Contact Officer: David Ongkili - 9399 0793
Your Ref: MP10_0044 MOD2
Our Ref: F2009/00460

SUBJECT LAND: 100-120 King Street and 30-36 Dangar Street, RANDWICK NSW 2031.
APPLICATION NO: MP10_0044 MOD2
PROPOSAL: Section 75W Modification Request to the Concept Plan for the Sir Moses Montefiore Jewish Home.

I refer to the above modification request by the proponent dated 9 December 2016 relating to Building D. Following a review of the Modification Request, Council makes the following comments:

LEVEL 5: SECOND FLOOR

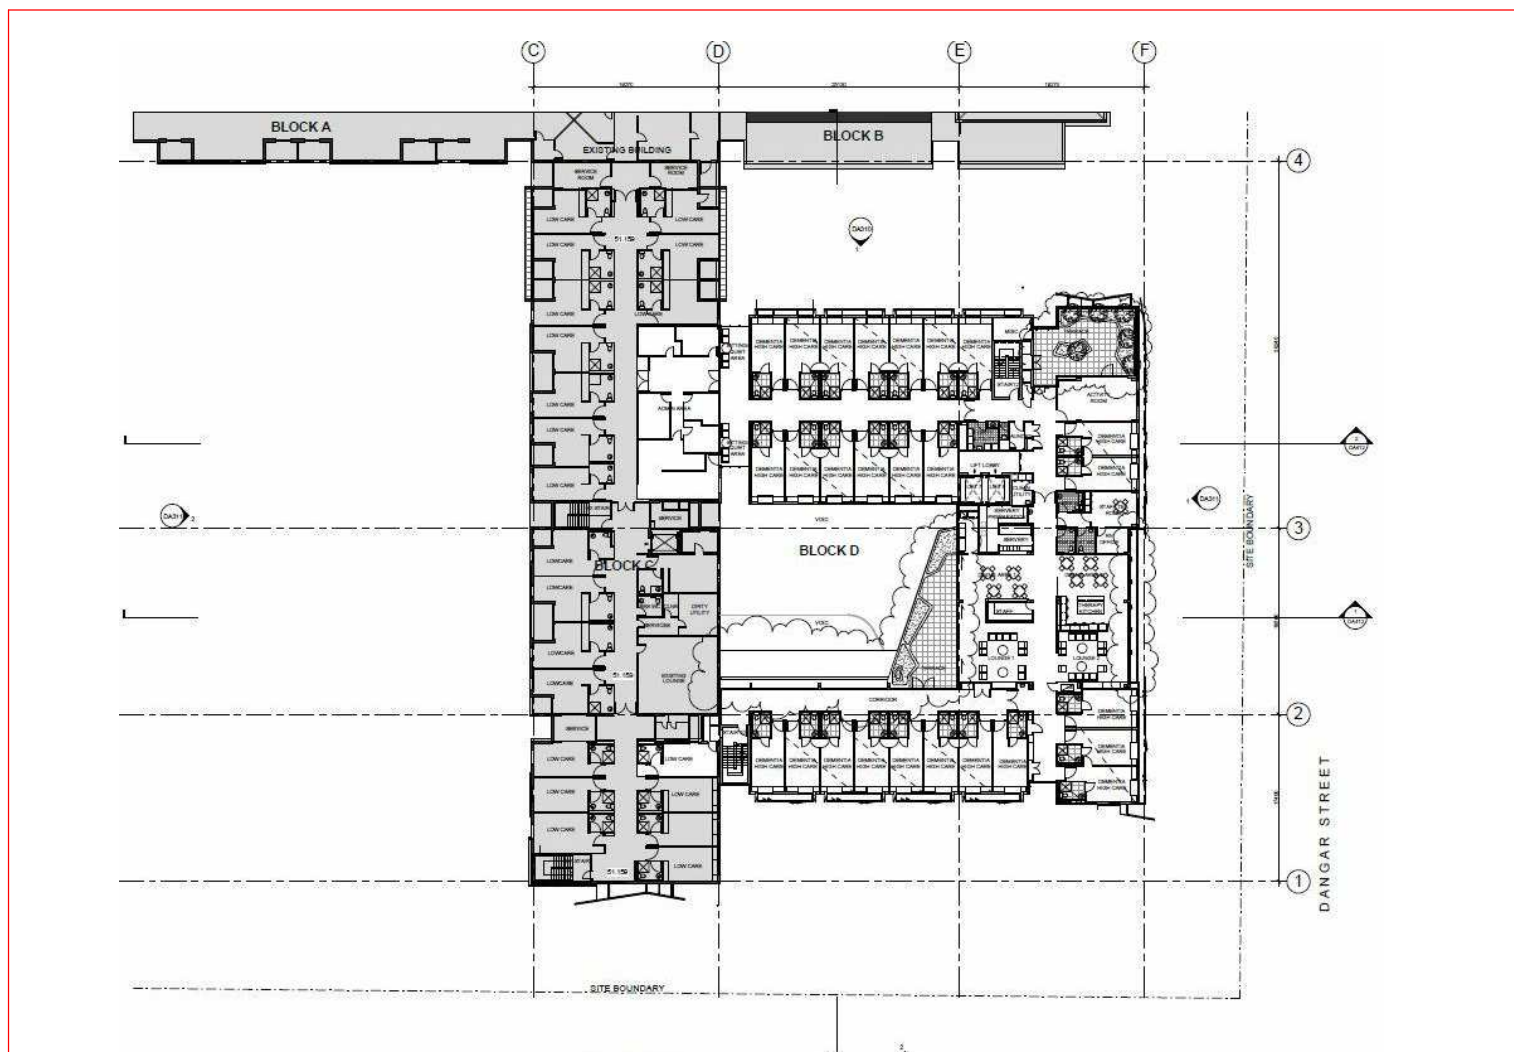
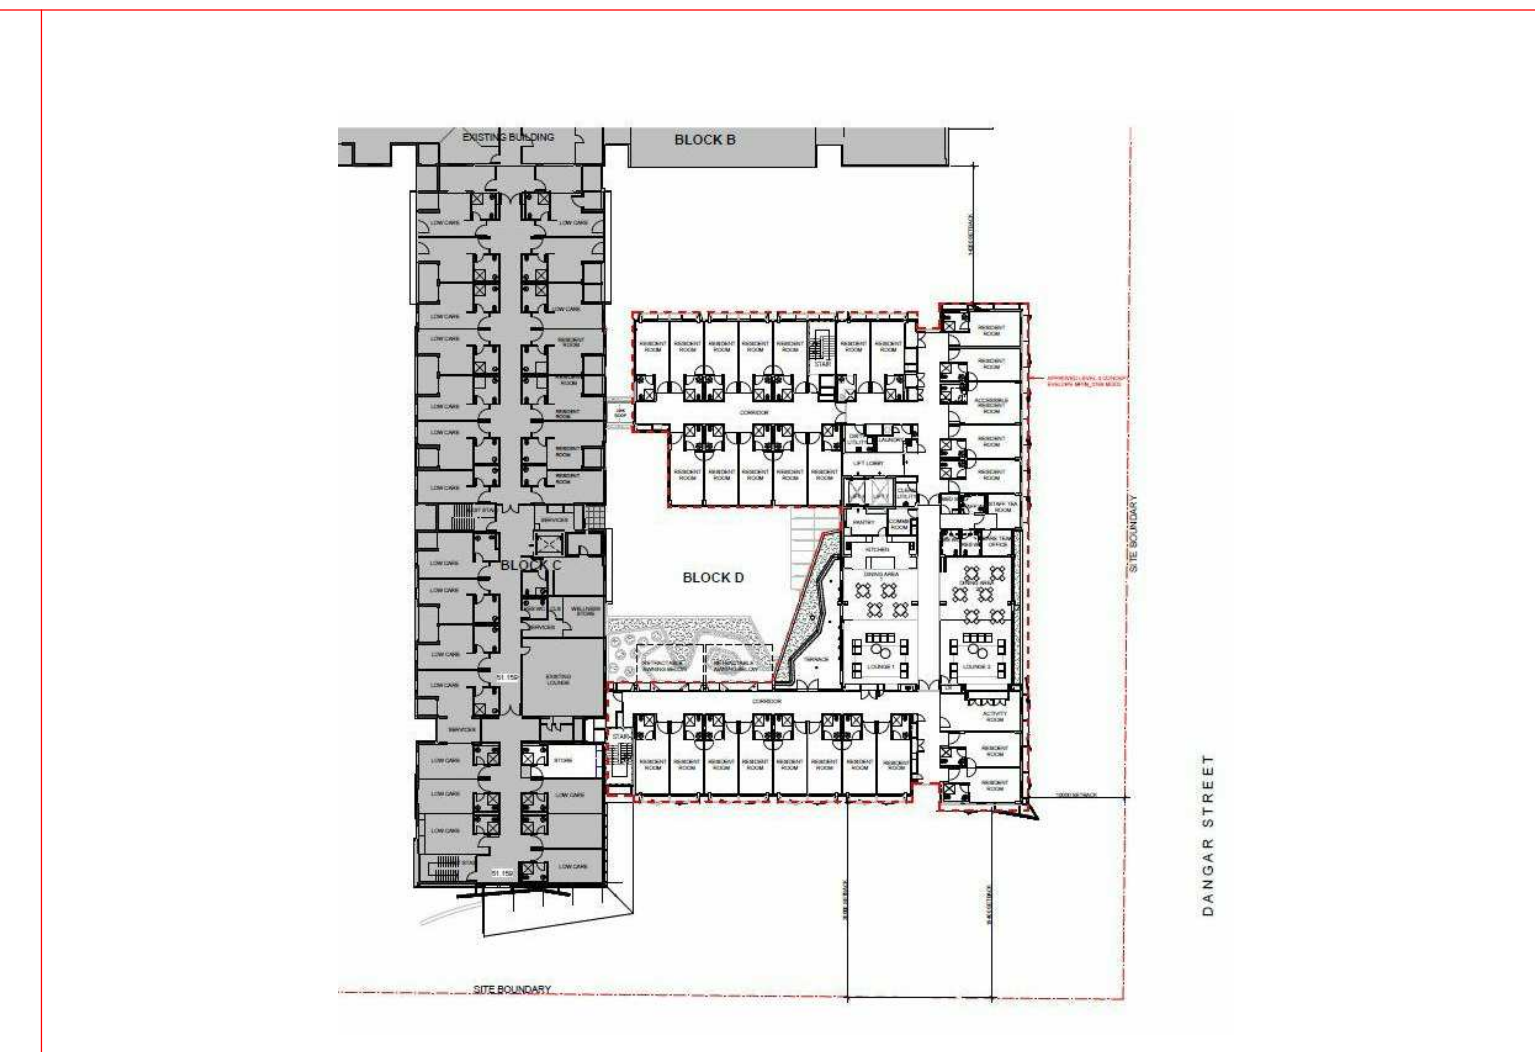
The modification involves deletion of approved terrace areas on Level 5 and replacement with dementia care rooms. Council raises concerns that the deletion of these communal areas would detrimentally affect the amenity of residents within the facility. Council also queries whether the amount of terrace area may have been understated as the approved concept plan also identified a significant terrace area along the southern wing of Level 5 which will be converted to dementia care rooms but apparently not referred to in the modification proposal (circled red in Figure below).

LEVEL 7: ROOF PLAN AND PLANT

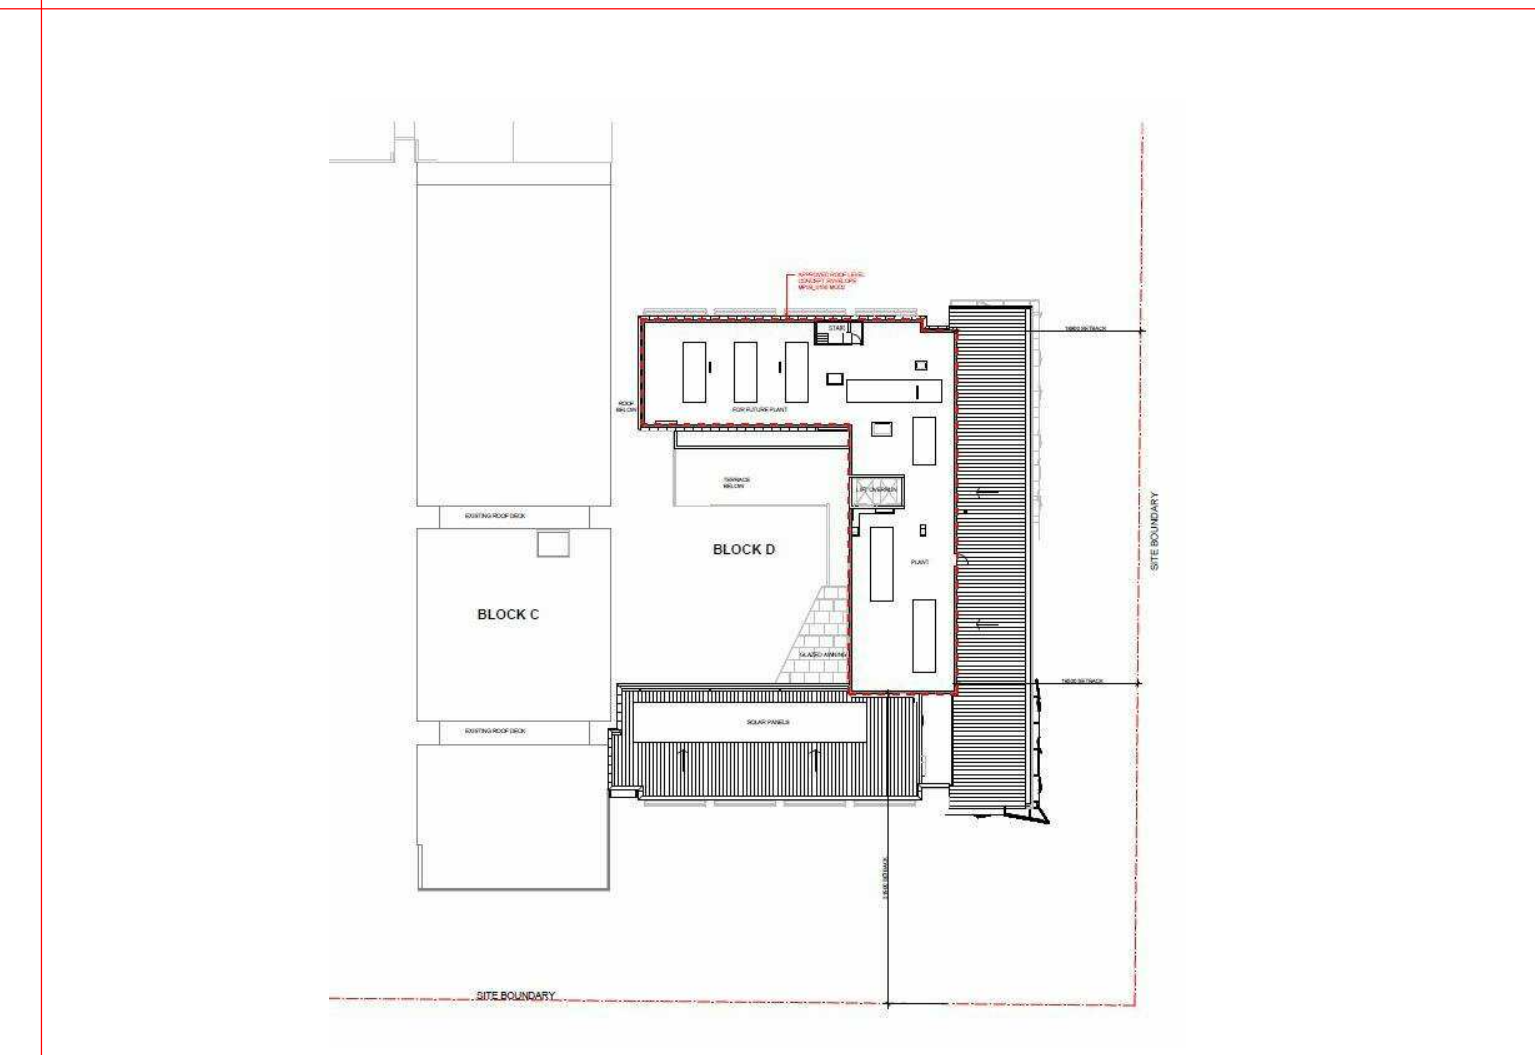
Additional Level 7

Council notes that, among other things, the modification proposal will be modified to include an additional level (Level7) in Building D to house plant rooms. This proposed level is a new level but will have a maximum height compliant with the approved maximum building envelope height of RL61.63 for Building D under the Concept Plan modification approval MP09_0188 MOD 2. Notwithstanding this, it will entail a further modification to visually screen the new level that will extend outside the Concept Plan envelope approval comprising:

- A 515mm protrusion of façade screen above the envelope established under the Concept Plan modification approval MP09_0188 MOD 2
- A 770mm parapet extension along the King Street frontage of Building D above the envelope established under the Concept Plan modification approval MP09_0188 MOD 2.

Council raises concerns at these incremental protrusions above the approved Concept Plan building envelope as they add to the visual bulk and scale of the overall building when view from the main streets. While the proponent argues that the increase in height are minor and limited to Building D, the overall incremental increase in these areas are considered intrusive and confirms Council's concerns in past submissions of the potential for a creep in height as development is staged over the whole site in the future.

DATE	SCALE @ A1	DRAWN
07/07/10		CDS
PROJECT NUMBER	DRAWING NUMBER	ISSUE
2008116	DA123	B

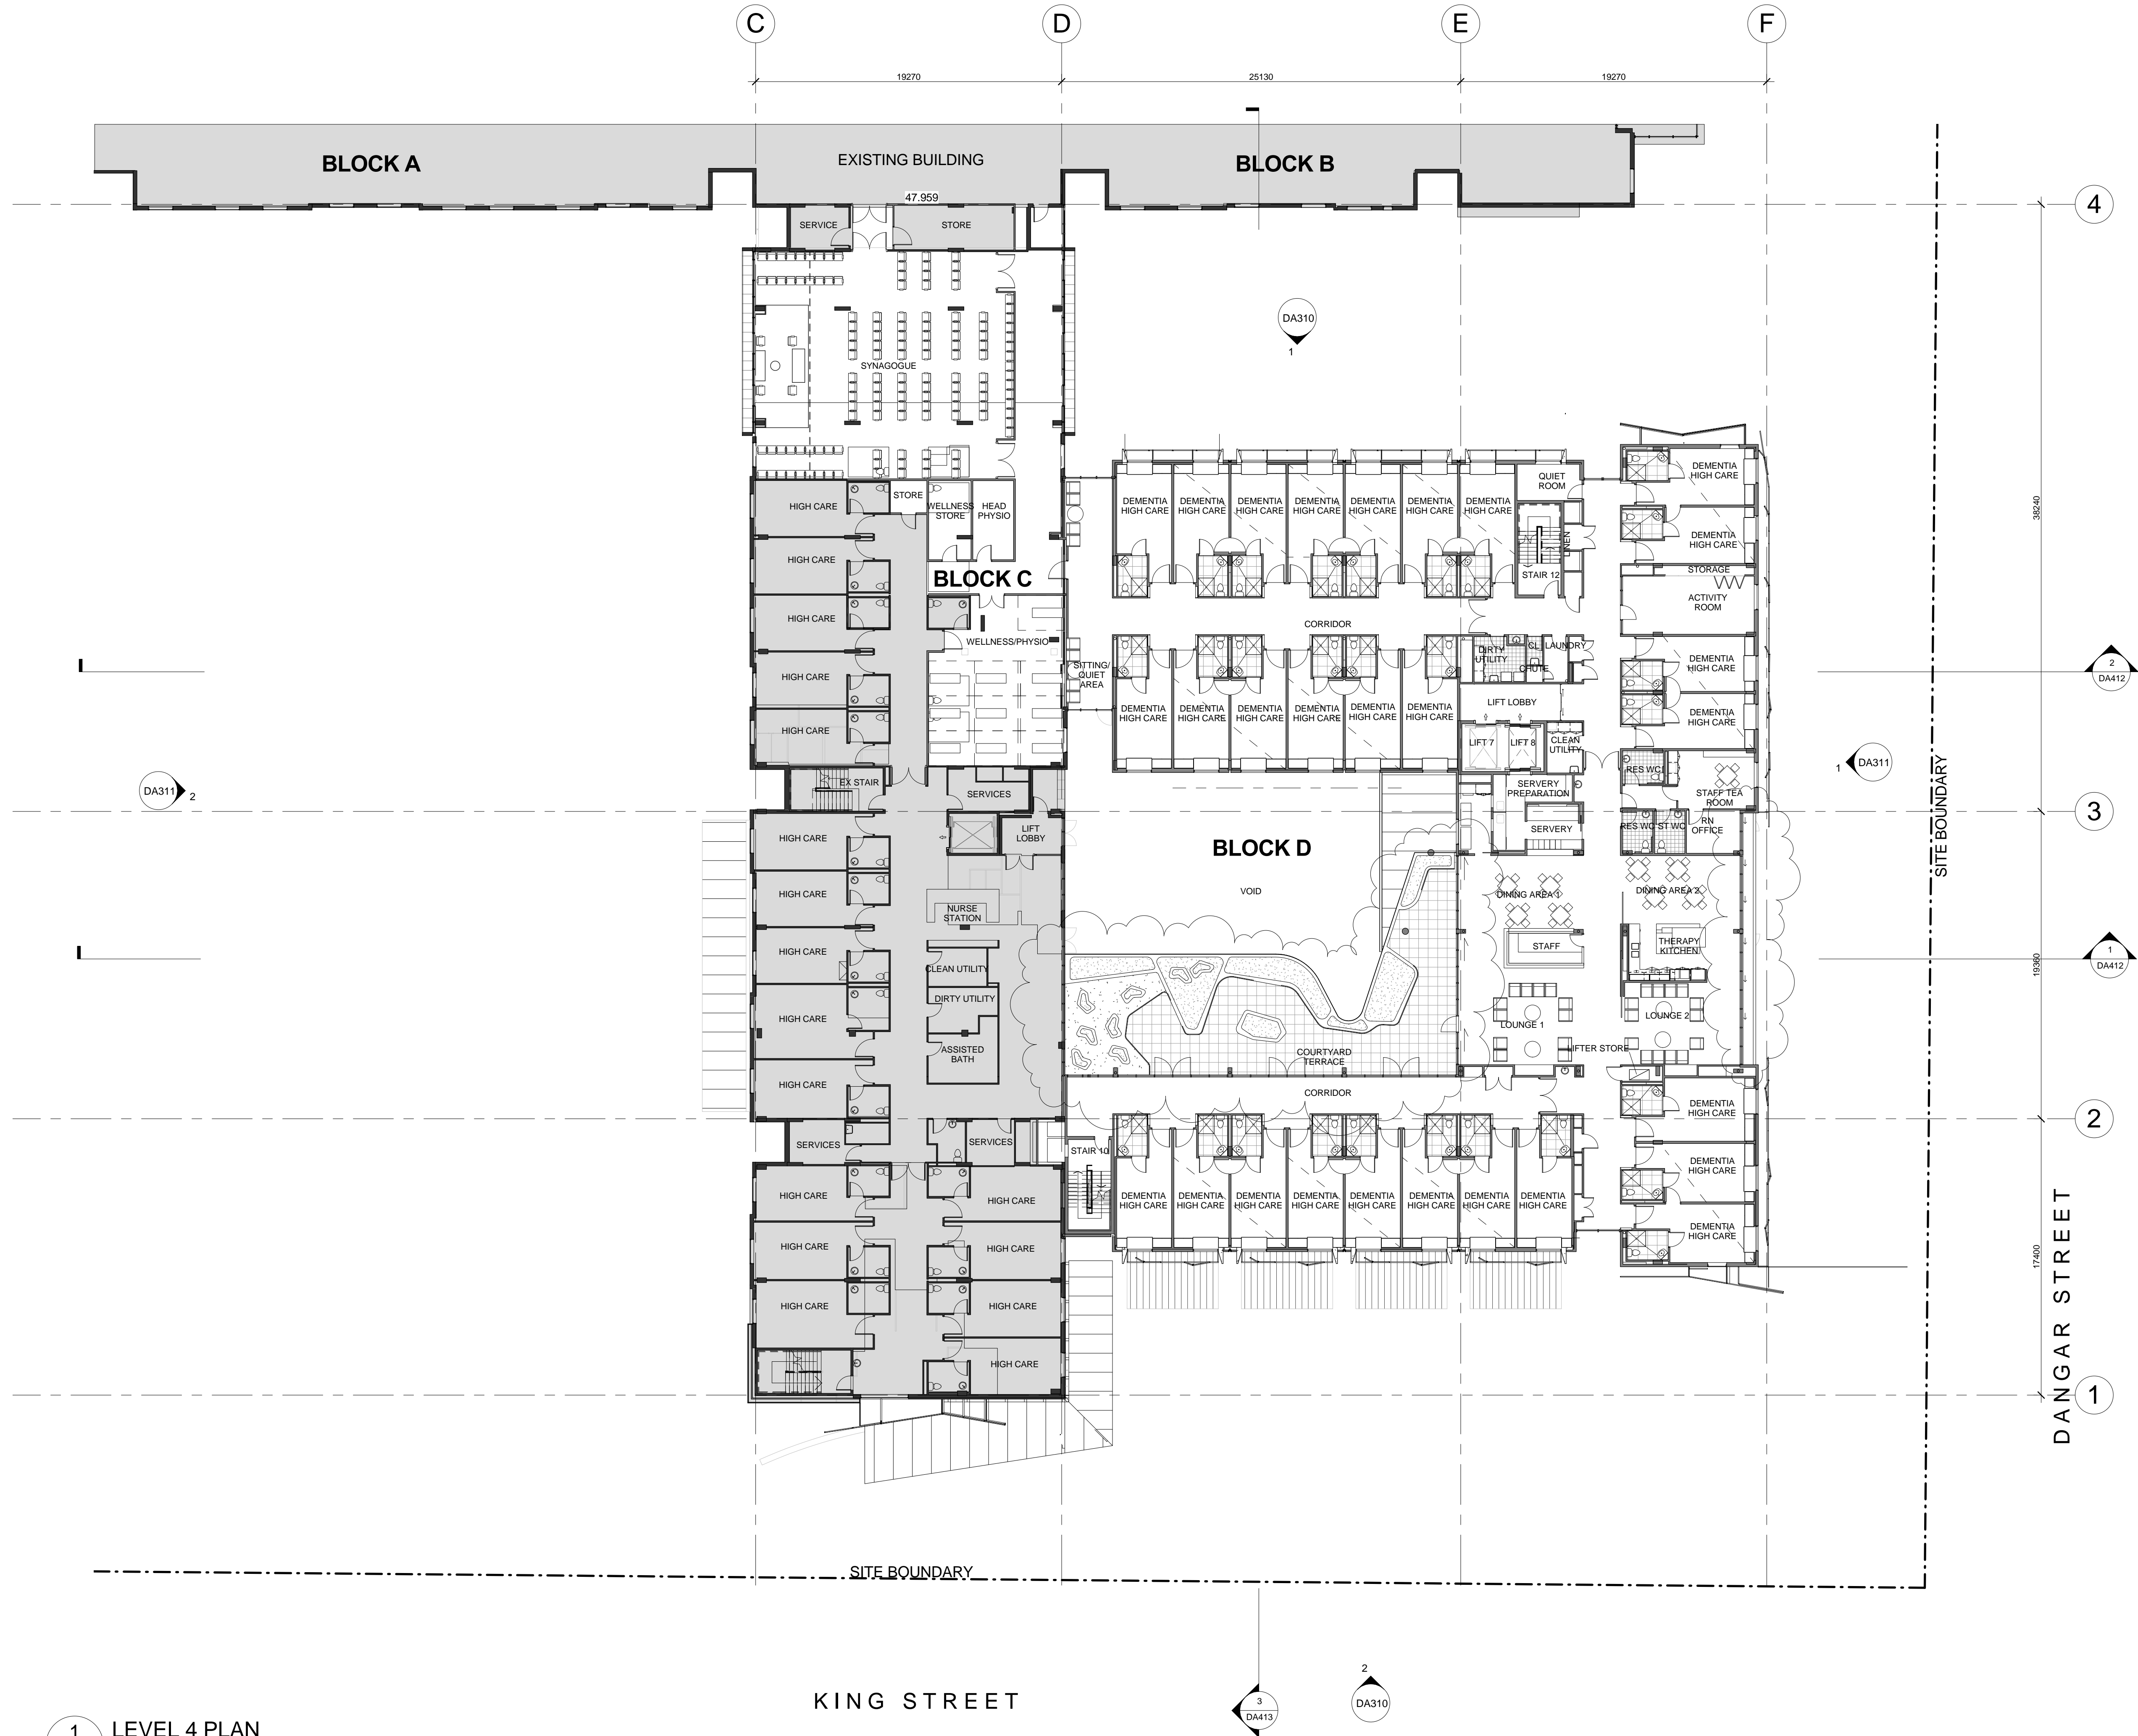
The modification proposal will reconfigure non-residential space and associated public plaza areas at Level 3 (ground floor). This non-residential space is referred to in the lodgement plan DA123 Issue 1 as "*Retail/Commercial/Community as per Concept Plan Modification Approval*". Council raises concerns at this description as it broadens the originally approved singular "retail" land use to allow for other commercial / community uses associated with the on-site Aged Care component thus potentially diminishing the overall retail area. It should be noted that in

- An increase in the floor area of the non-residential component that potentially goes against the original objective of LEP amendment.
- An exclusivity in use of these non-residential components for only the Montefiore community and not retail uses for the wider community contrary to the original objective of the LEP amendment.

It should be further noted that the broadening of land uses within this designated retail area is contrary to the Concept Plan modification approval MP09_0188 MOD 2 which clearly marks this area purely as "Retail" in approved Drawing No. MA2.04Rev.1.

The current proposed modification retains an awkward linear configuration for the adjoining public square that impedes its function for passive recreational or spontaneous activities. In previous submissions on this matter, Council has consistently advised that consideration should be given to the depth of the plaza to allow for passive recreational; improving its geometric configuration and creating a terminating vista of higher quality to Church Street. In particular, Council has concerns that an elongated configuration will not be useable as a public open space for the community contrary to the regular configuration of a proposed public square under the Master Plan and development consent. Council maintains that the function, form and performance of the proposed public square should consider the public streetscape and surrounding community that this facility is located in and is a part of.
